Our Case Number: ACP-323849-25

Re: The proposed development is for a mixed use development that seeks the regeneration and adaptive reuse of a strategic brownfield site, as part of the Limerick City and County Council 'World Class Waterfront revitalisation and transformation project' 'Cleeves Riverside Quarter' in the townland of Farranshone More in Limerick City.

Formal Observation / Objection

To: An Coimisiún Pleanála
Re: Proposed Development — Cleeves Riverside Quarter / Cleeves Riverside Campus
Applicant: Limerick Twenty Thirty DAC
Location: Former Cleeves Factory Site, North Circular Road, Limerick

Figure 3a (top) and Figure 3b (bottom) illustrating 10 minute catchment from site

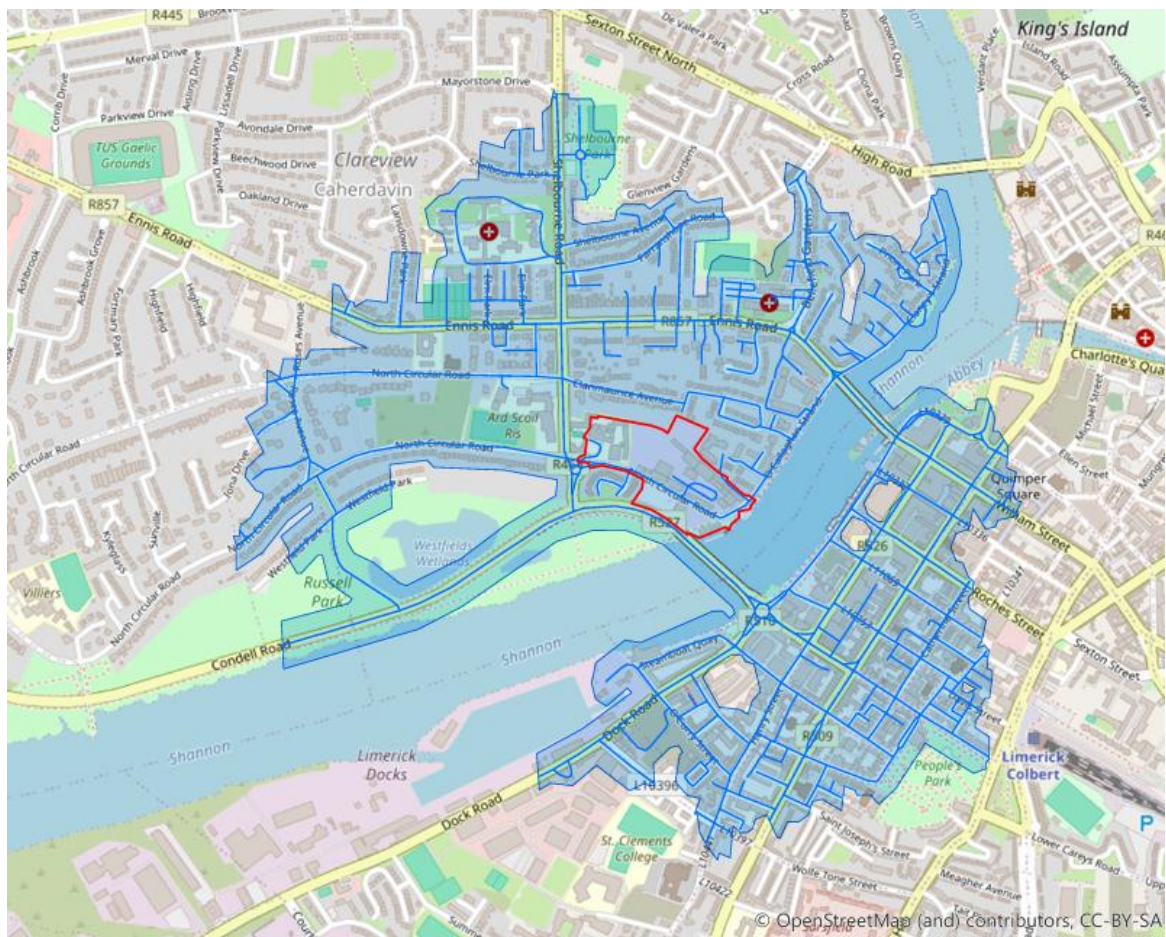
These inaccuracies continue to occur, for example the ***Sustainability and Social Infrastructure Statement*** produces various maps and data sets based on distances of 10min walk time. Figures 3a and 3b are perfect examples of these inaccuracies. On those particular maps; (on the south) the map indicates a walk time of 10min to the junction of Upper Mallow street and the R858 (Actual walk time according to Google Maps of 18 min) That map and others, (from which supporting data is derived), exaggerates distance (based on 10min walk time) north, south, east and west of the proposed development.

I request (1) that all inaccuracies based on distances and location of services be corrected and that all data derived from these inaccuracies (and subsequently) used to support this planning application be corrected with only the corrected information being used in consideration of this application.
